Planning Application Ref: P/24/20/RES

Location: Land North of Sefter Road & 80 Rose Green Road, Pagham

Comments on Application:

Drawing Title:-
SW DRAINAGE STRATEGY

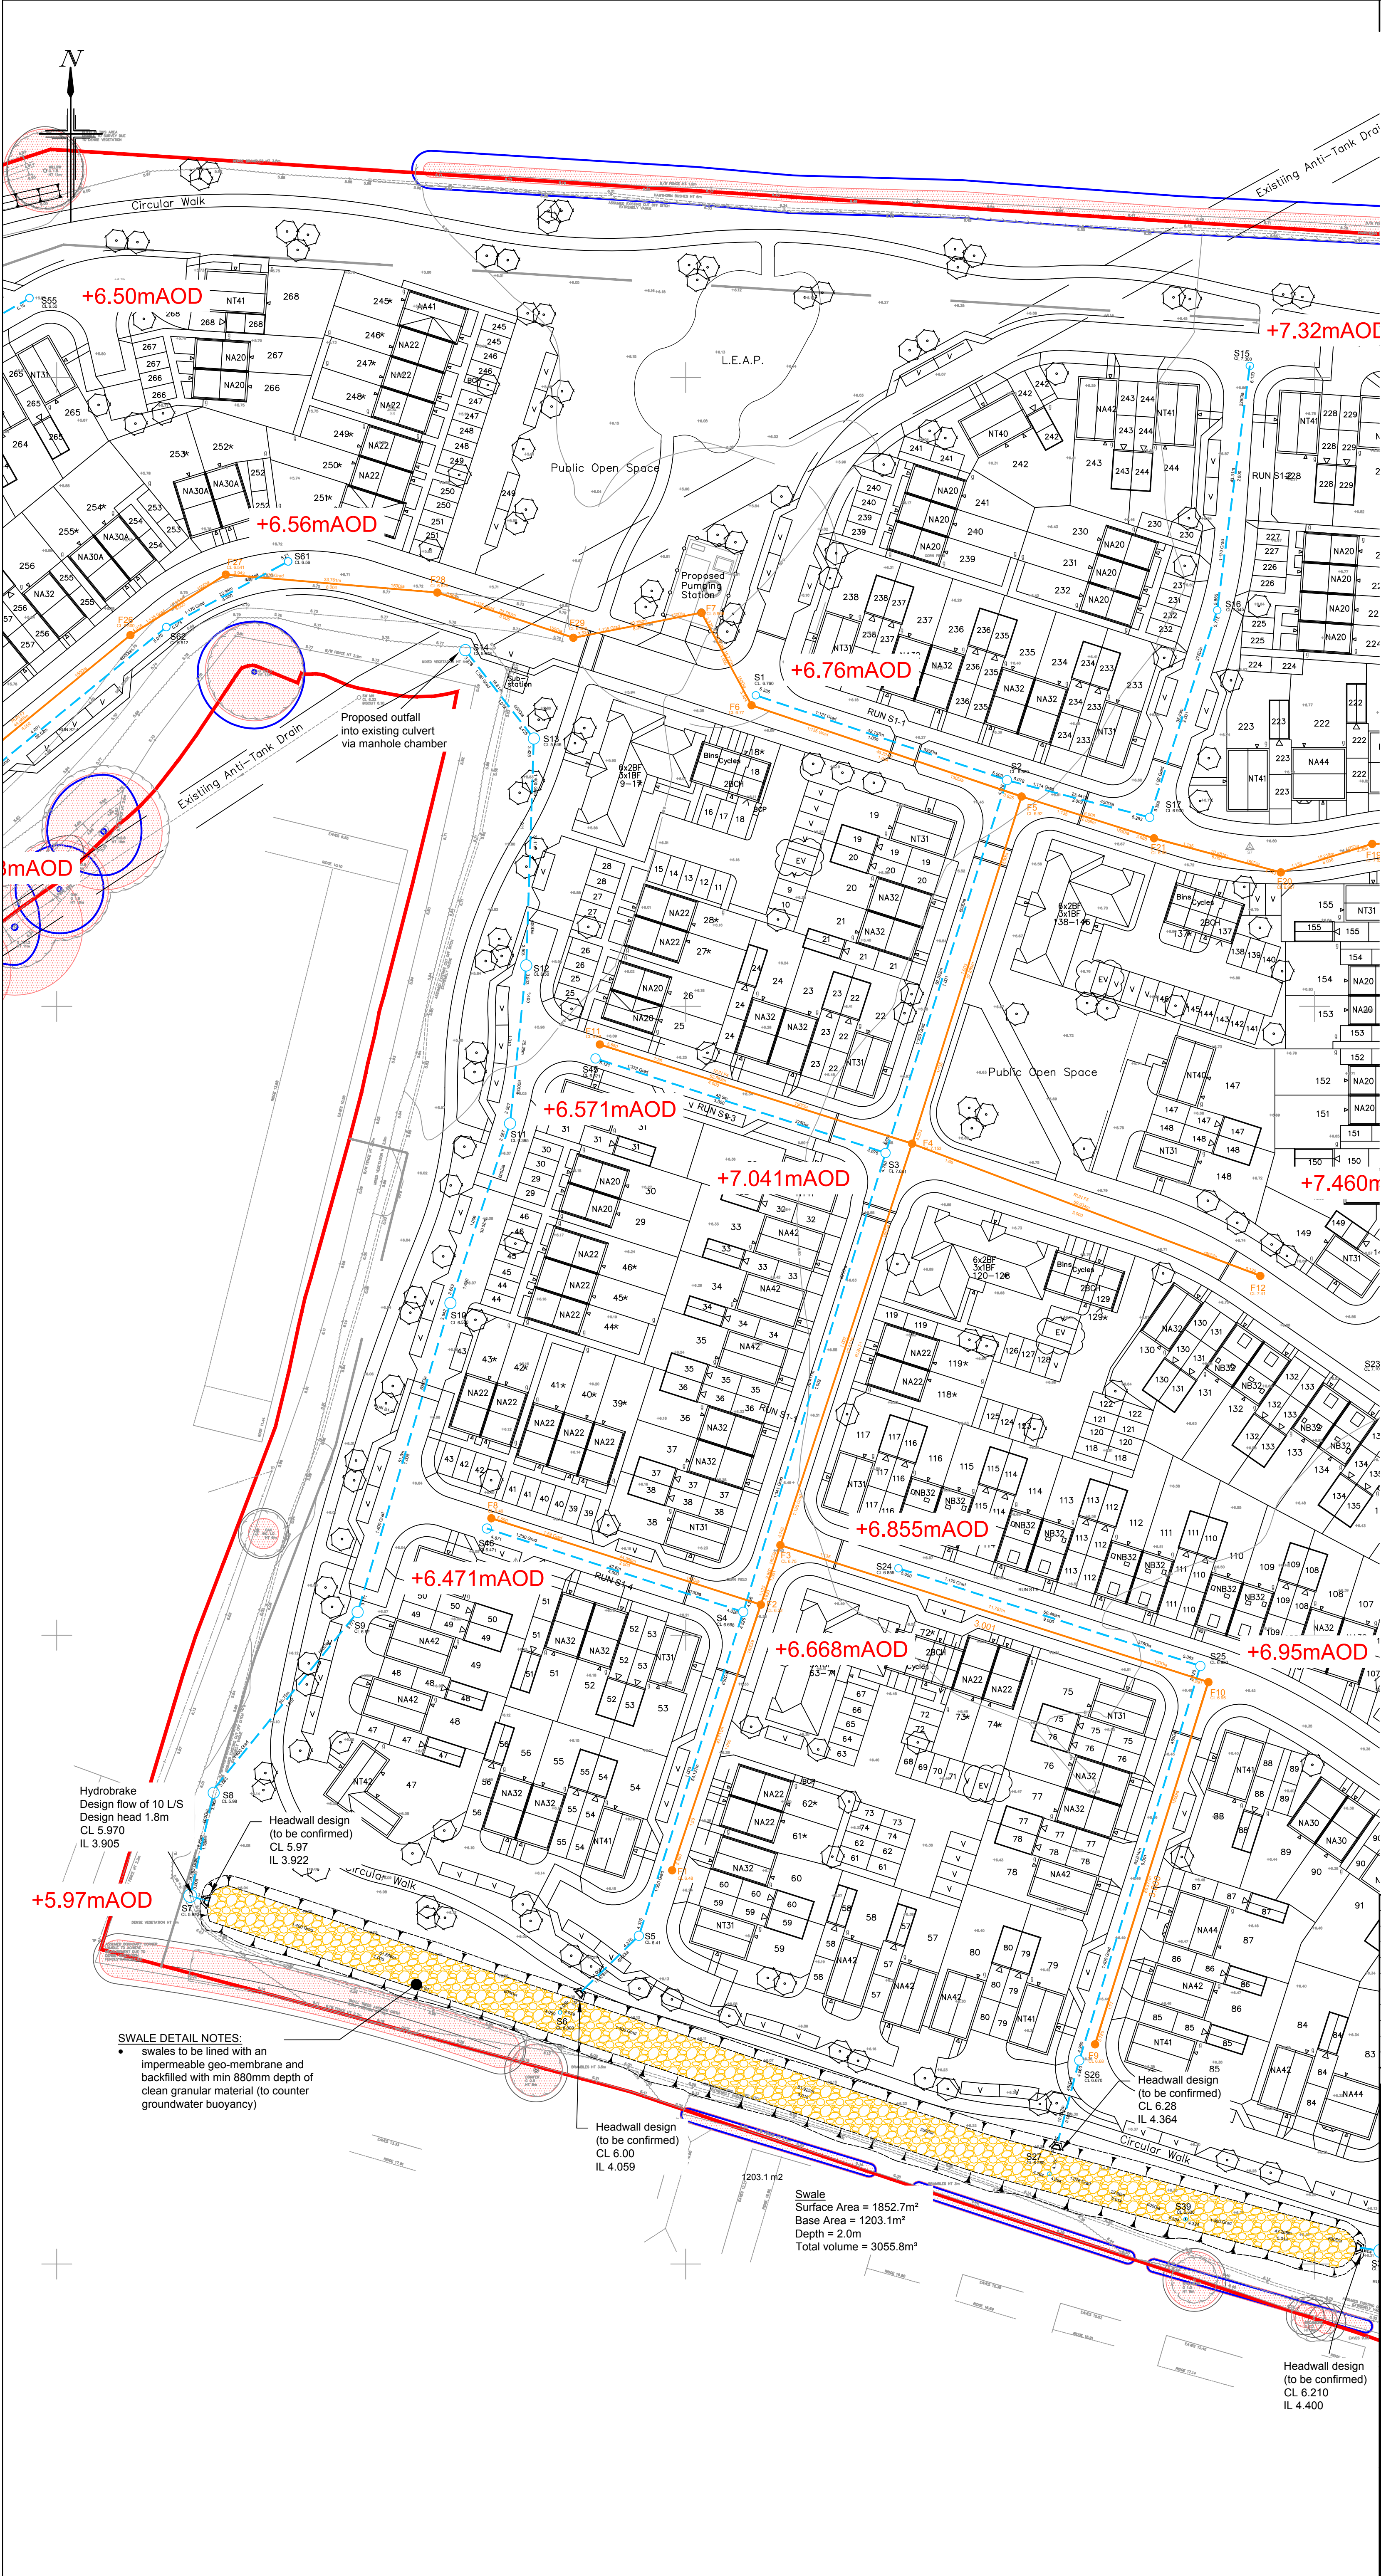
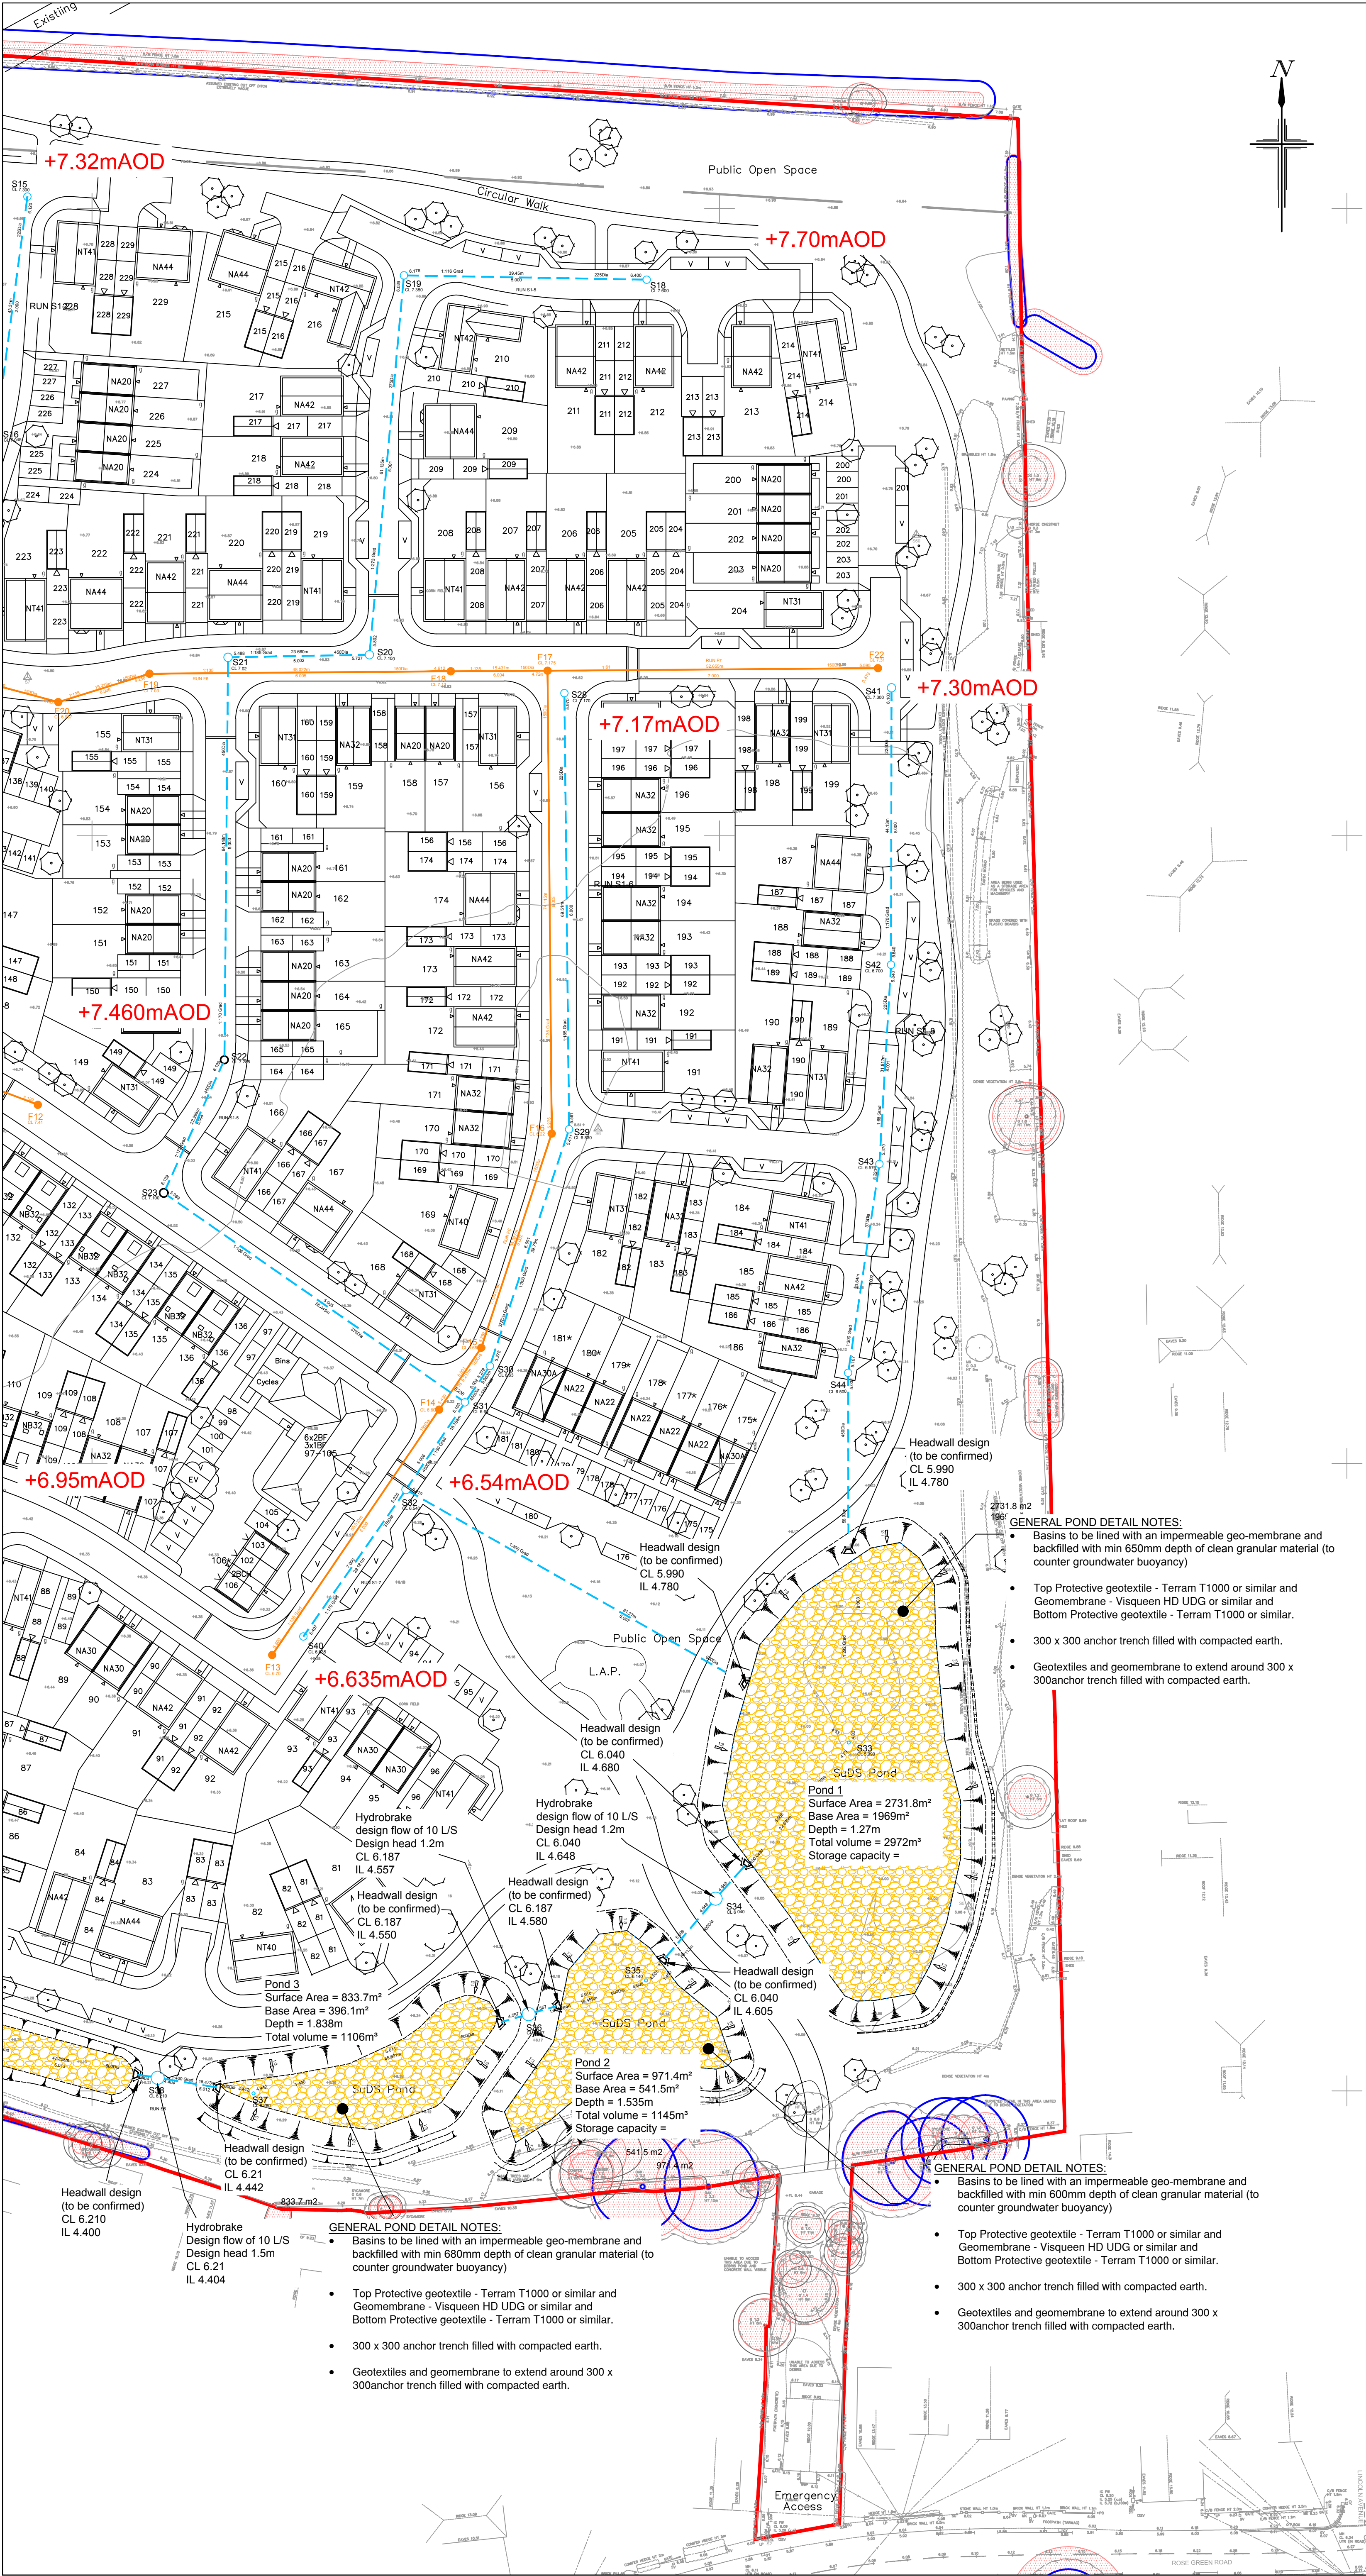
- Insufficient regard to existing and potential growth of trees (the subject of Tree Preservation Order) from the siting of SuDS ponds 2, 4 & 5 and the location of attenuation tank. These will need to be tweaked slightly to allow for min. 3m easement outside of RPAs (plus 2m buffer zone) or relocated within the site.
